LIBERTY TREE ACADEMY - PHASE 2

CONSTRUCTION DOCUMENTS

TOWN OF PEYTON, EL PASO COUNTY

LIBERTY TREE ACADEMY - PHASE 2				
TOWN OF PEYTON, EL PASO COUNTY CONSTRUCTION DOCUMENTS, PCD FILE NO. PPR-20-018				
TITLE SHEET				
DESIGNED BY:	ACR	SCALE	DATE ISSUED:	DRAWING No.
CHECKED BY:	DRK	HORIZ. NA VERT. NA	DECEMBER 2020	TS01
			1 OF 19 SHEET

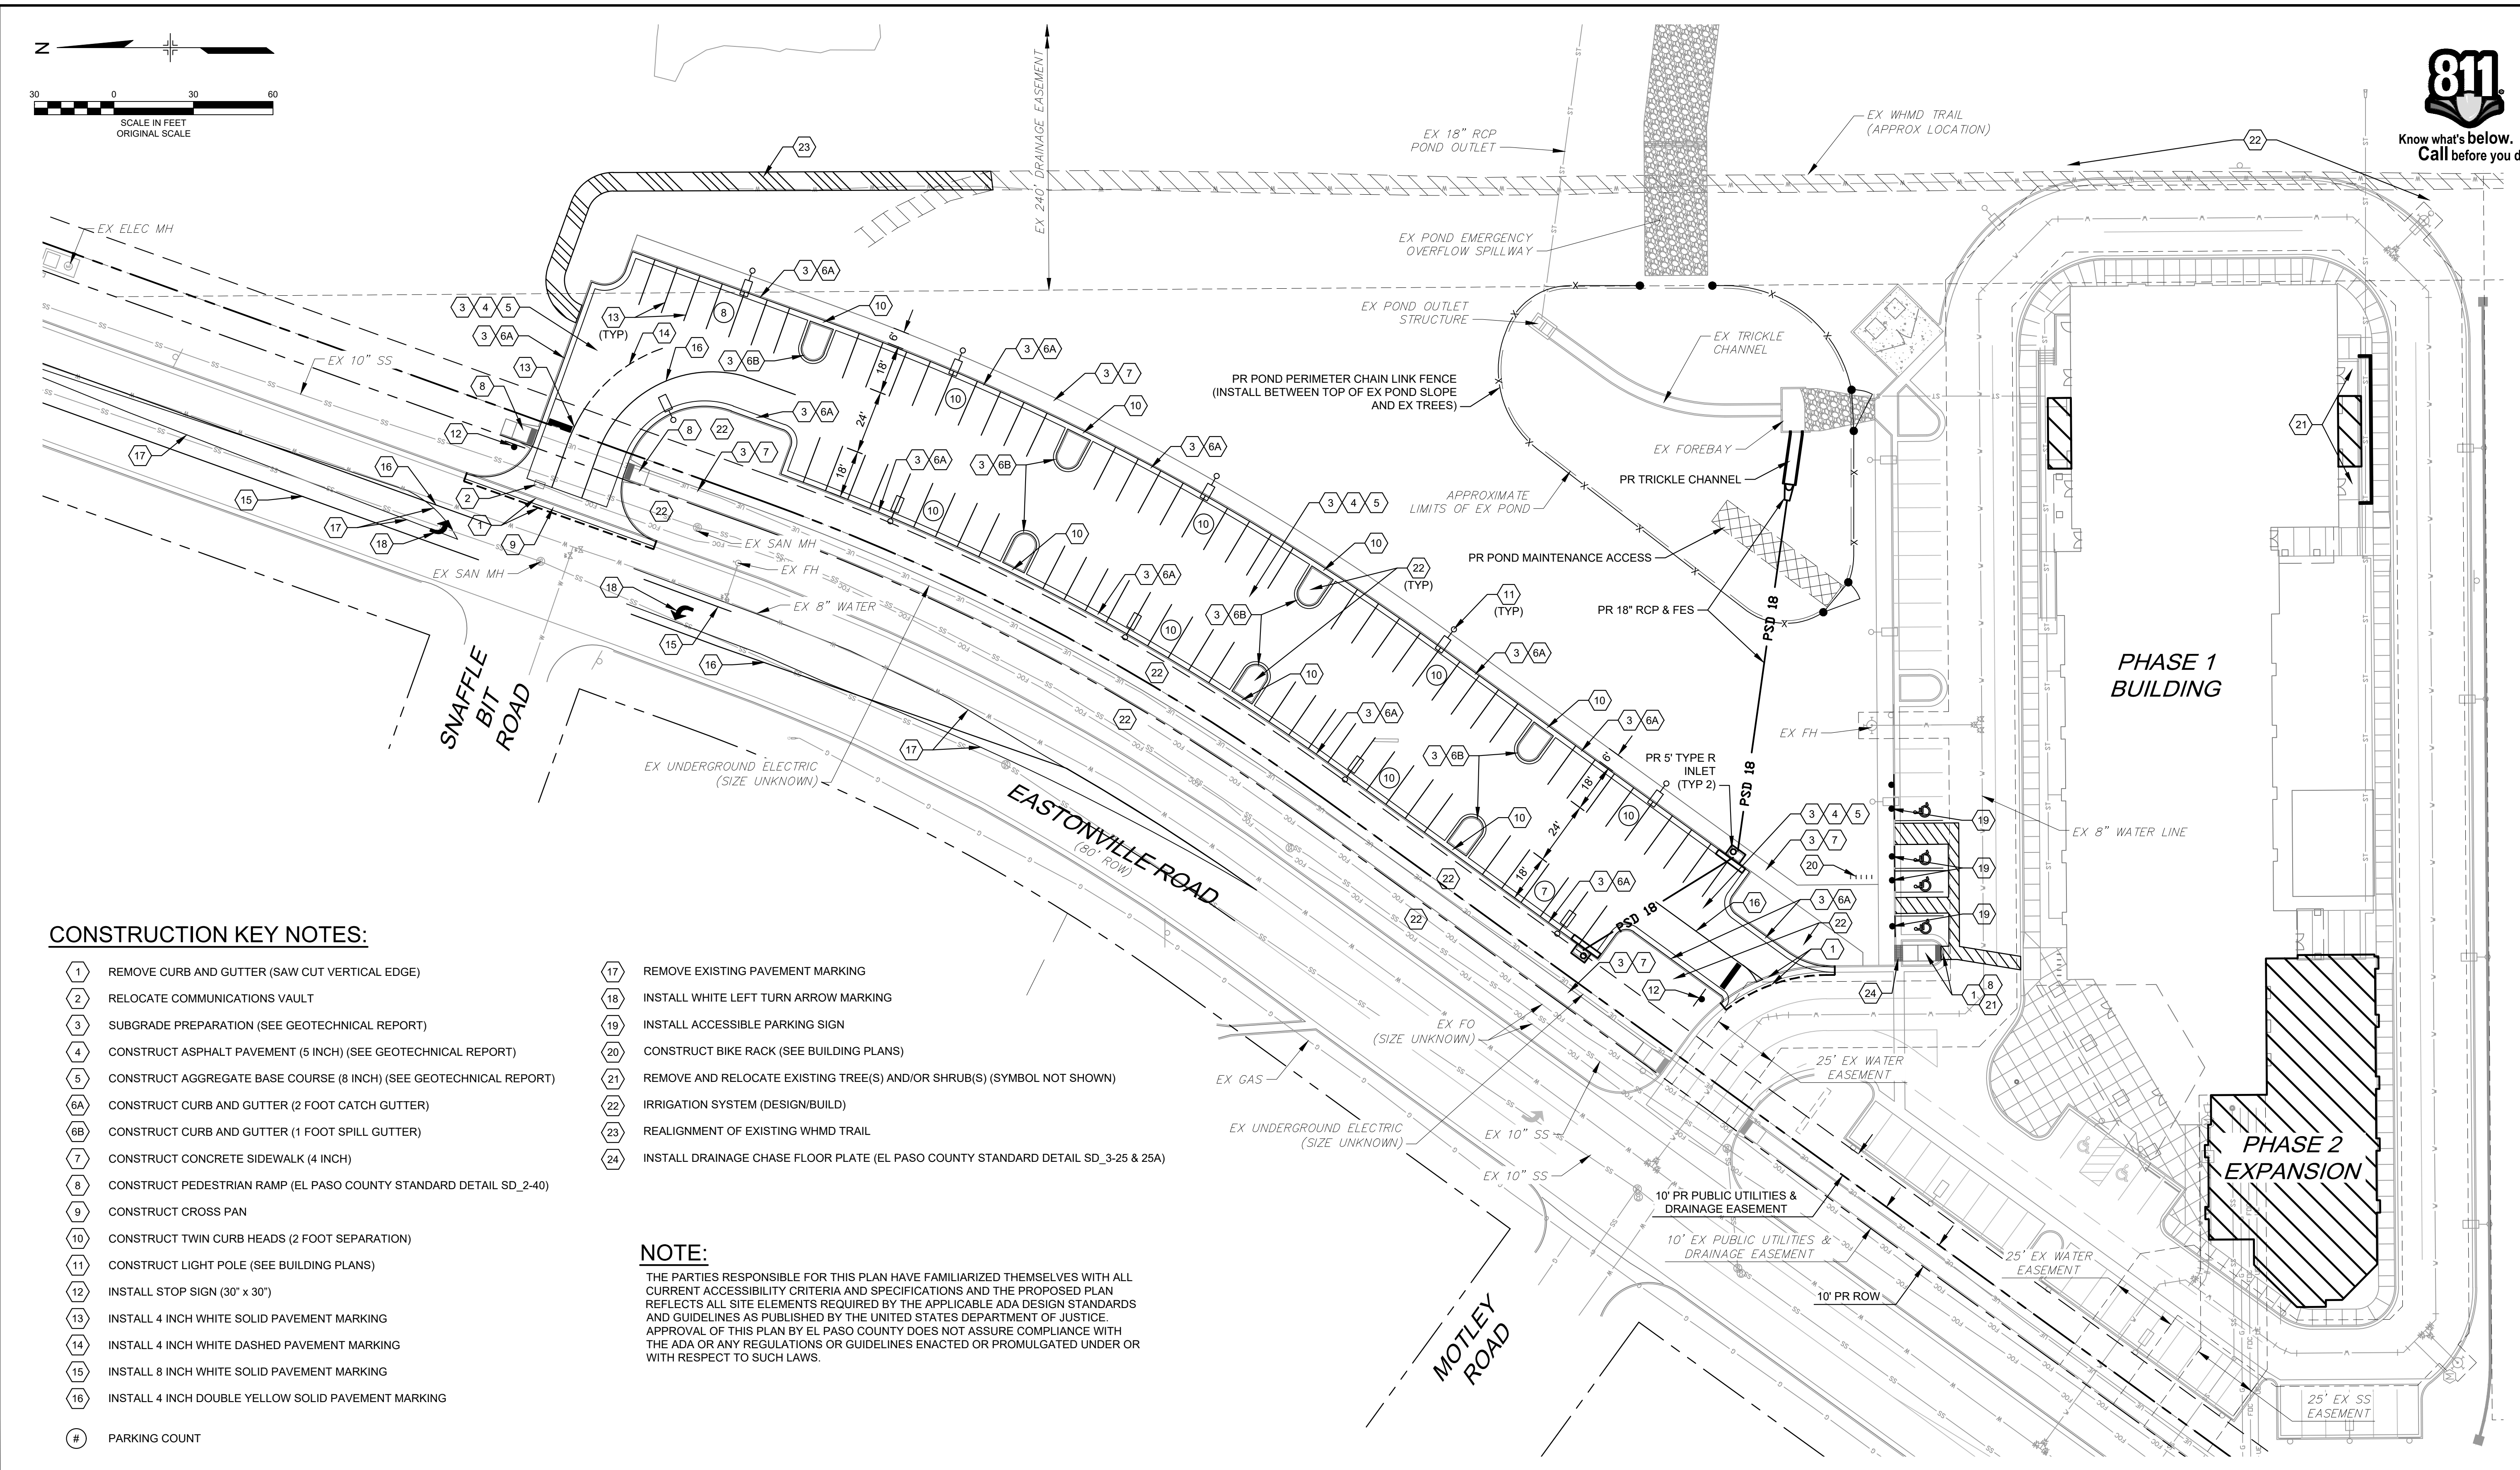
Please provide more information/ detail regarding the relocation of the existing sanitary sewer manhole. Please also show the new location relative to the proposed curb and gutter

**HORIZONTAL CONTROL PLAN**  
EPC 9/23/2020

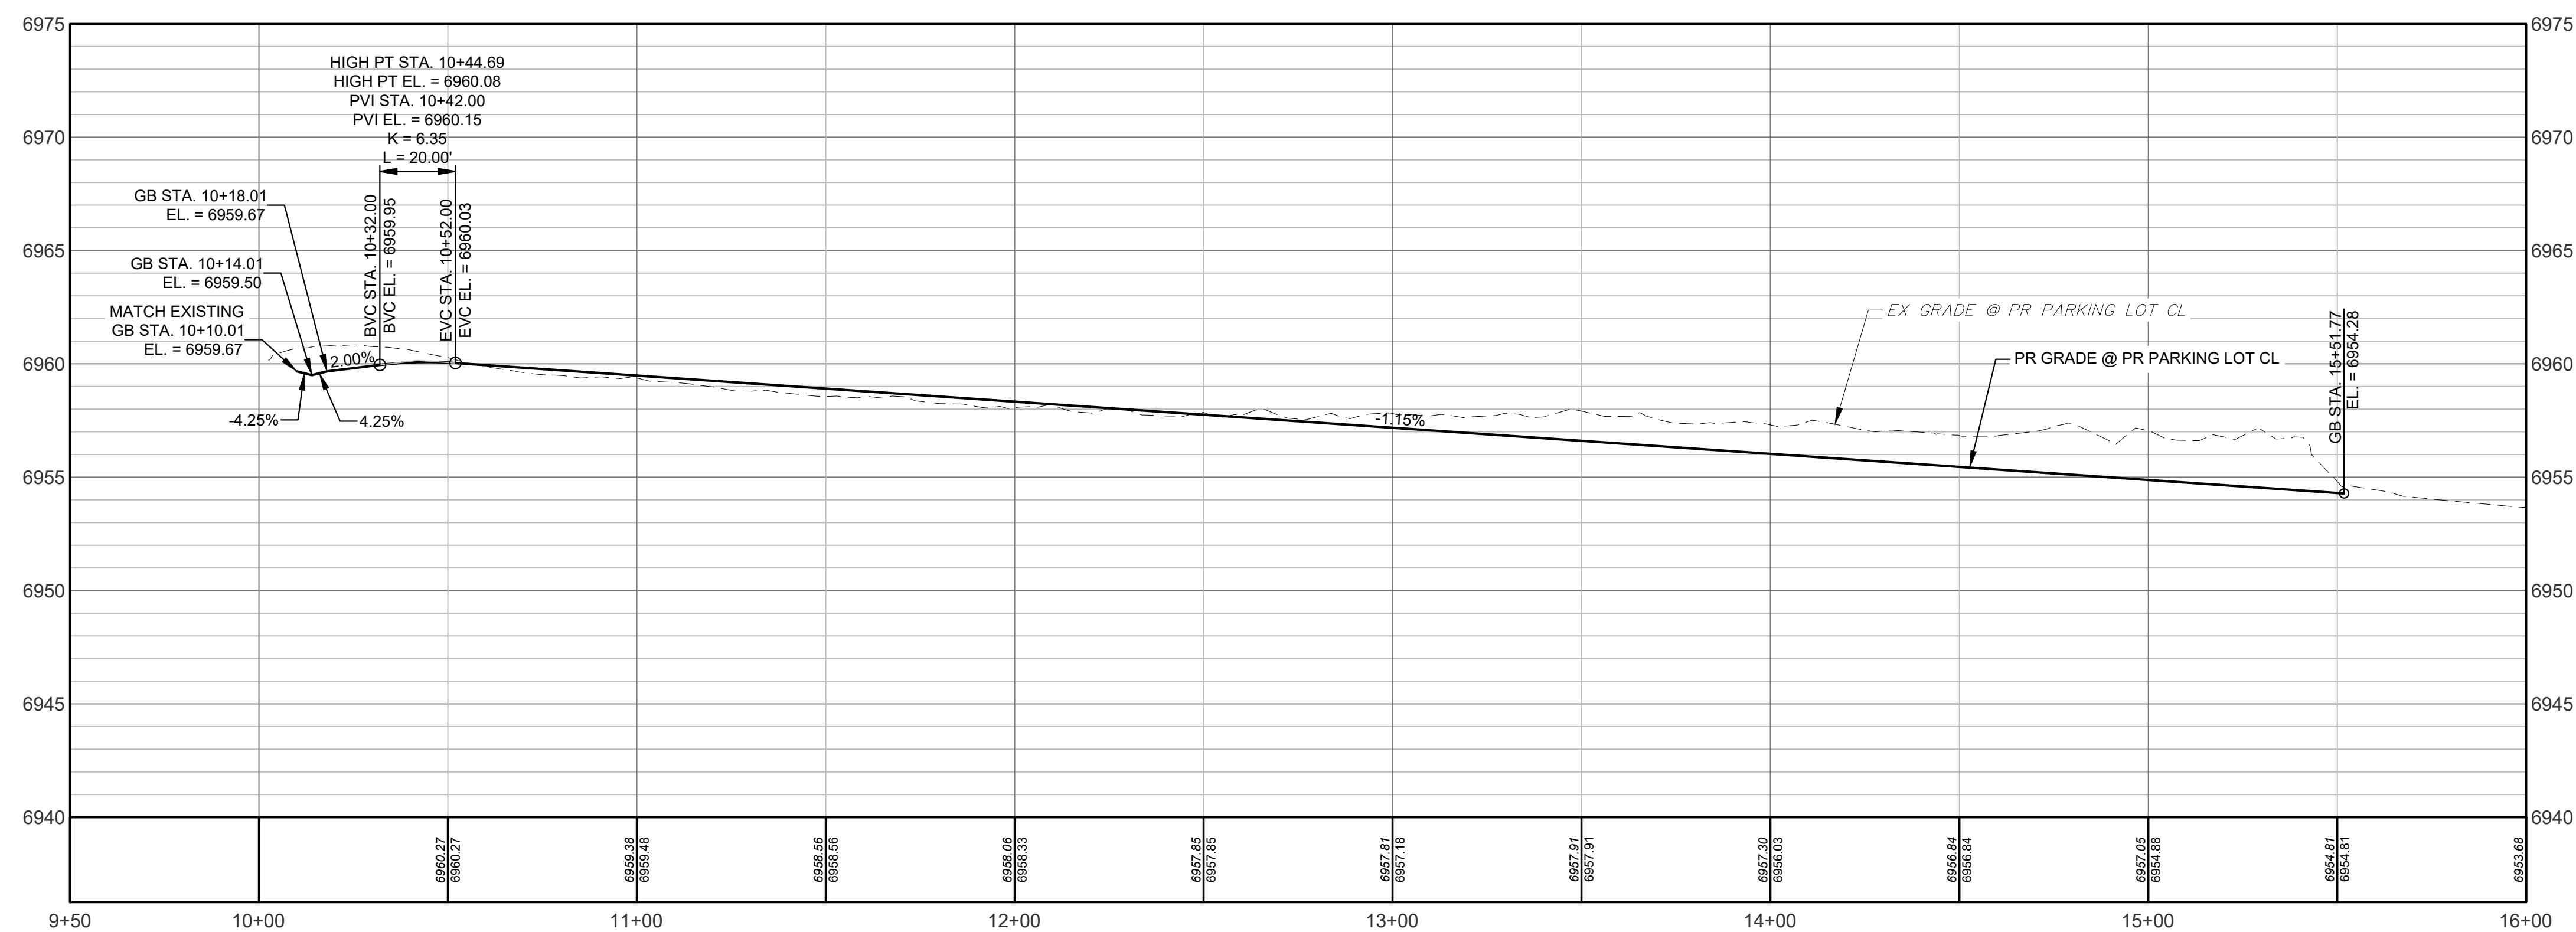
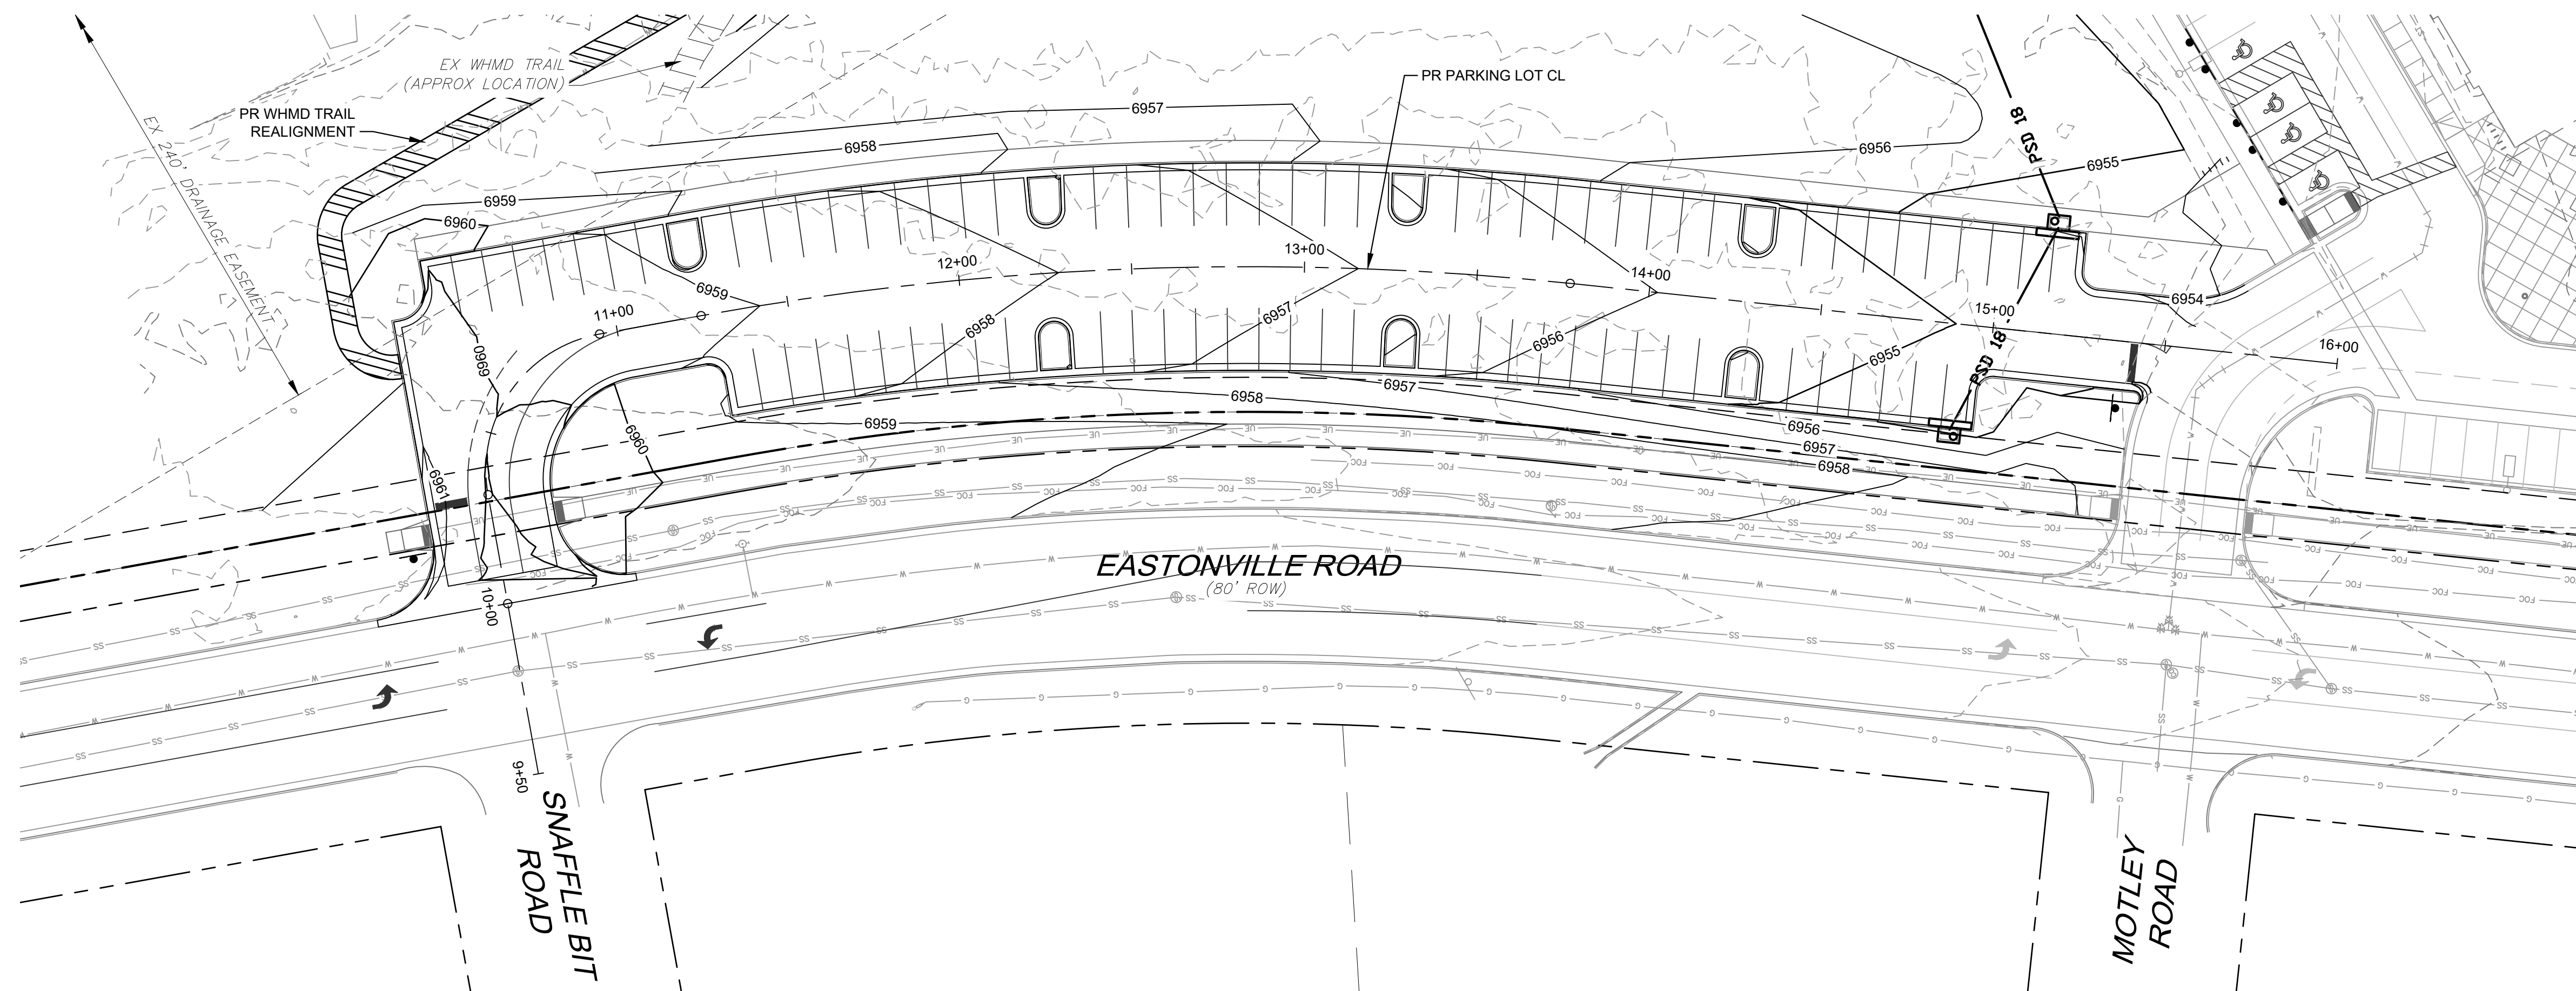
A comment was provided on the TIS to provide an autoturn exhibit. Please revise the curve radius of C1 & C23 as necessary.
